**From:** Brenda Larsen  
**Sent:** Wednesday, November 20, 2013 7:28 AM  
**To:** Jeff Watson  
**Subject:** RE: BL-13-00004 Winkle

Re: Winkle (BL-13-00004)

After conducting a review of the above named project, I have the following comments:

~~EXHIBIT~~  
PROPOSED

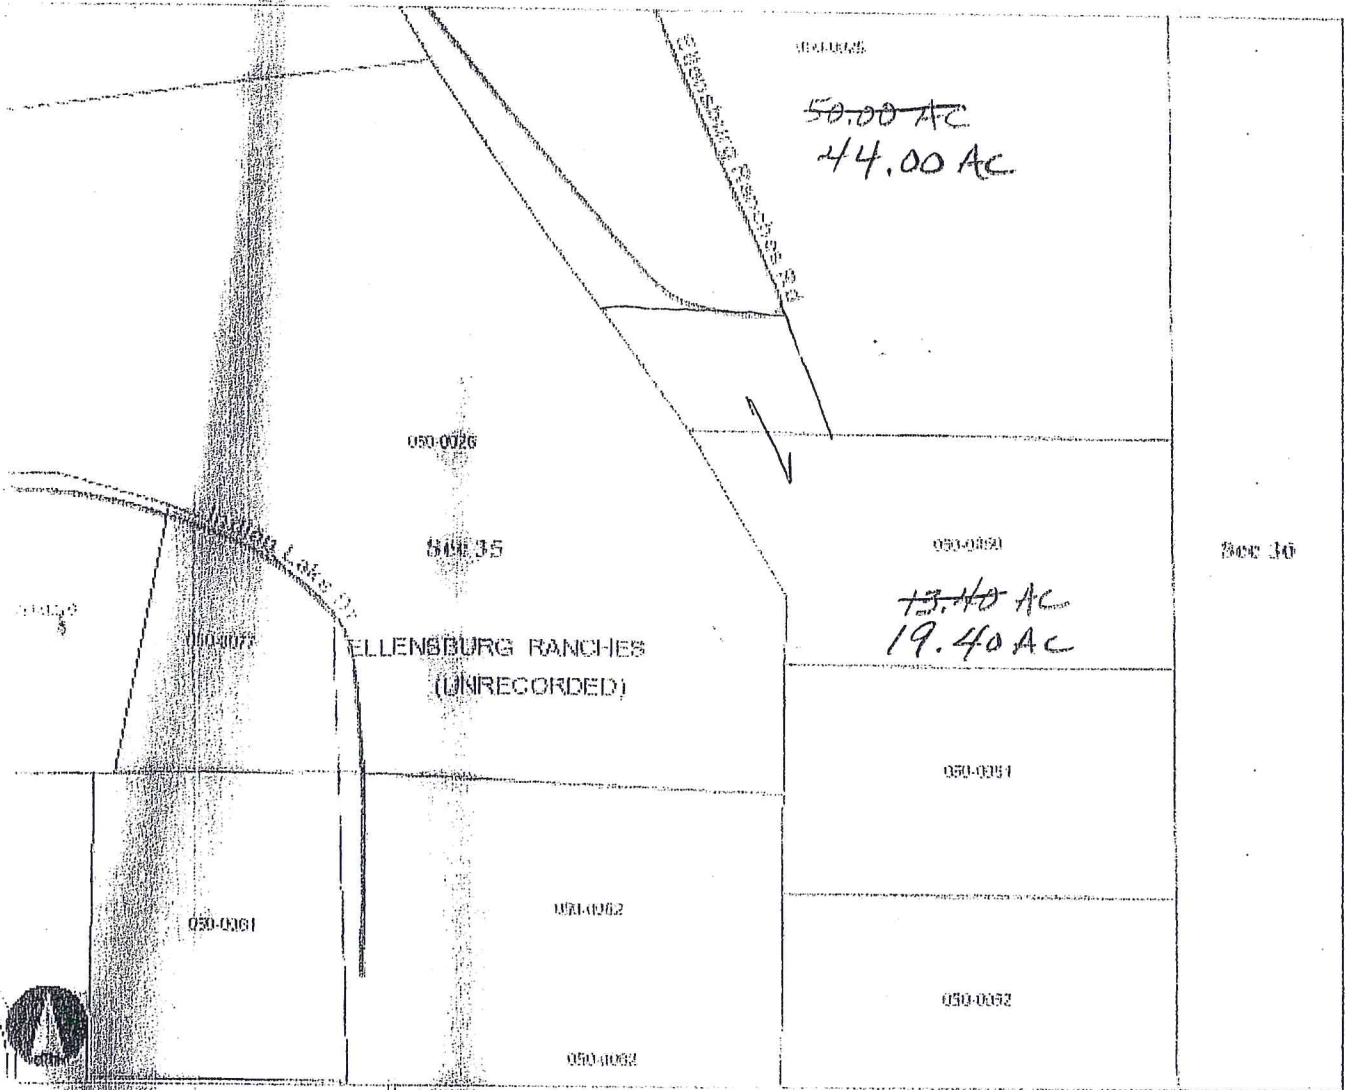
- Ensure that boundary line adjustments do not infringe upon existing structures, to include propane tanks, etc.
- Ensure adequate access for fire apparatus. Any driveways or access points created based off the new lot configurations shall comply with Kittitas County Code 20.02.030.
- All future development must comply with the International Fire Code.
